DOC17503581-01  
SSD 7610

10 November 2017

**SSD 7610 – INNER SYDNEY HIGH SCHOOL – RESPONSE TO SUBMISSIONS (RtS) REPORT**

SSD DEMOLITION PLANS
Ground Floor Plan

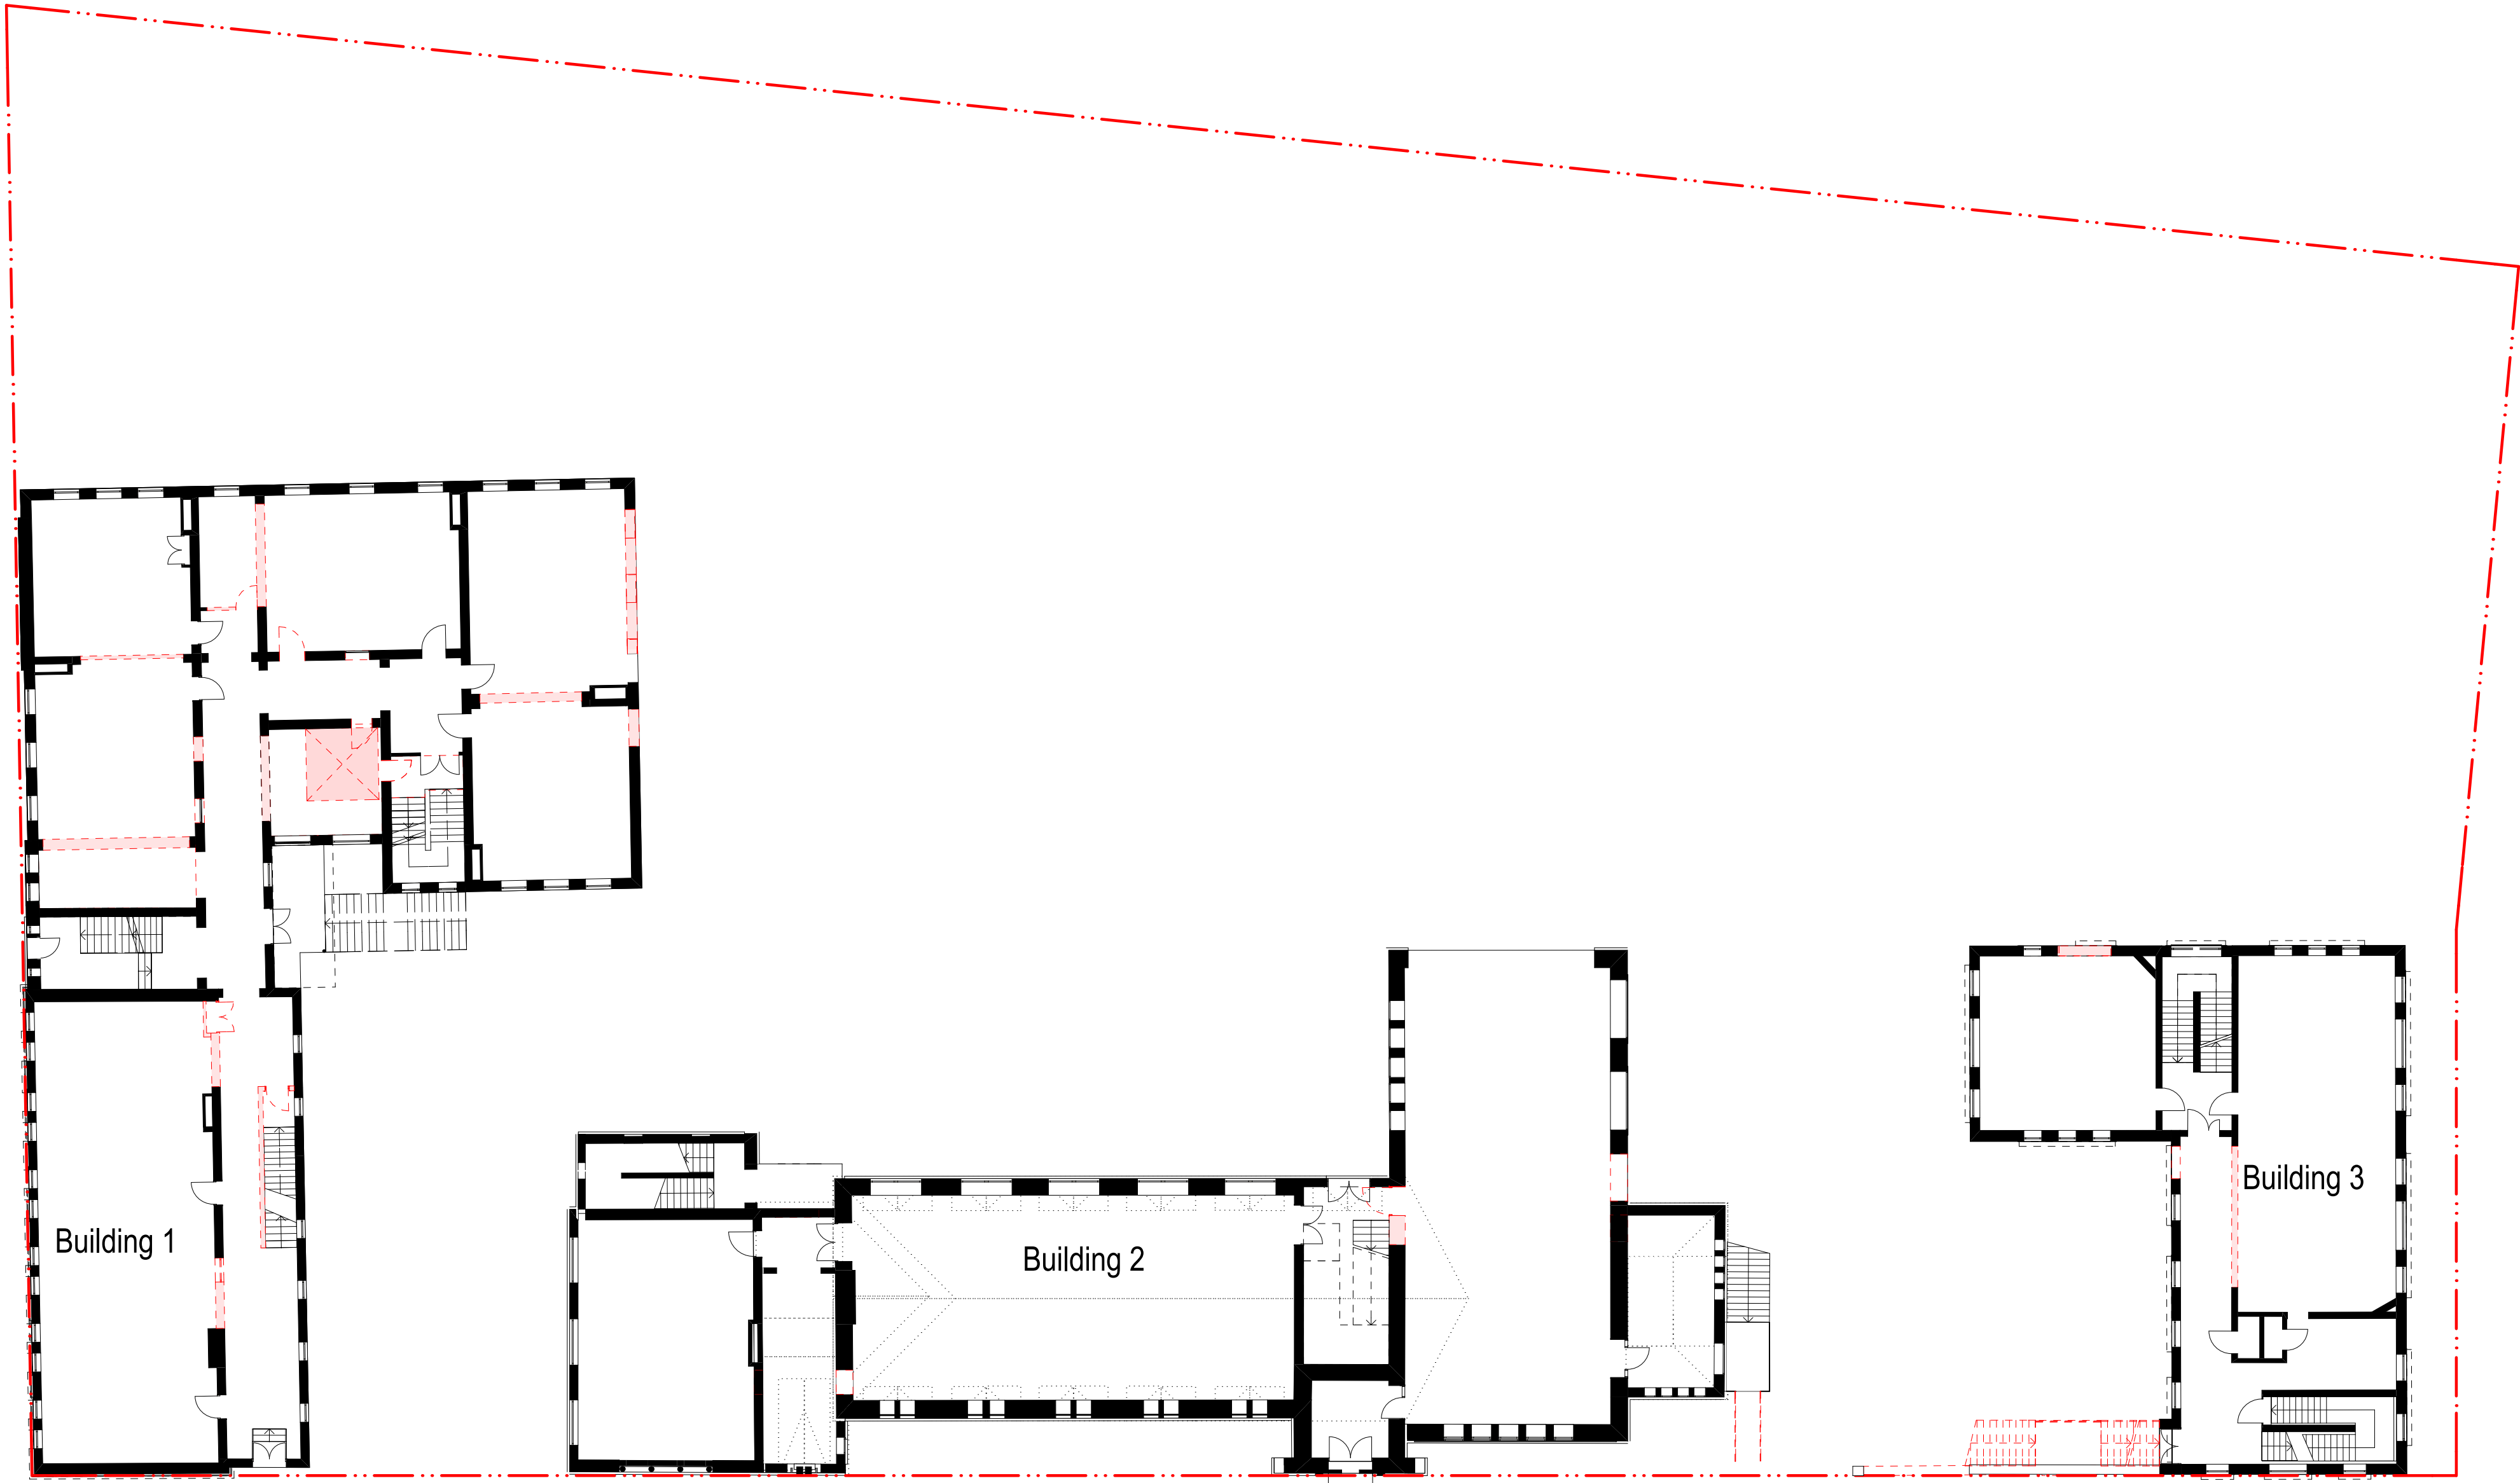
Demolition of Building 4

The EIS for the project indicated that demolition activities (and associated early works) would be undertaken pursuant to a separate development assessment process.

Nevertheless, the EPA's submission of 4 August 2017 concerning the project EIS highlighted its concerns that any demolition activities be undertaken in a manner consistent with the EPA's recommendations concerning subsequent stages of construction.

The EPA confirms its advice and recommendations subject to appropriate adjustment of the merged assessment process.
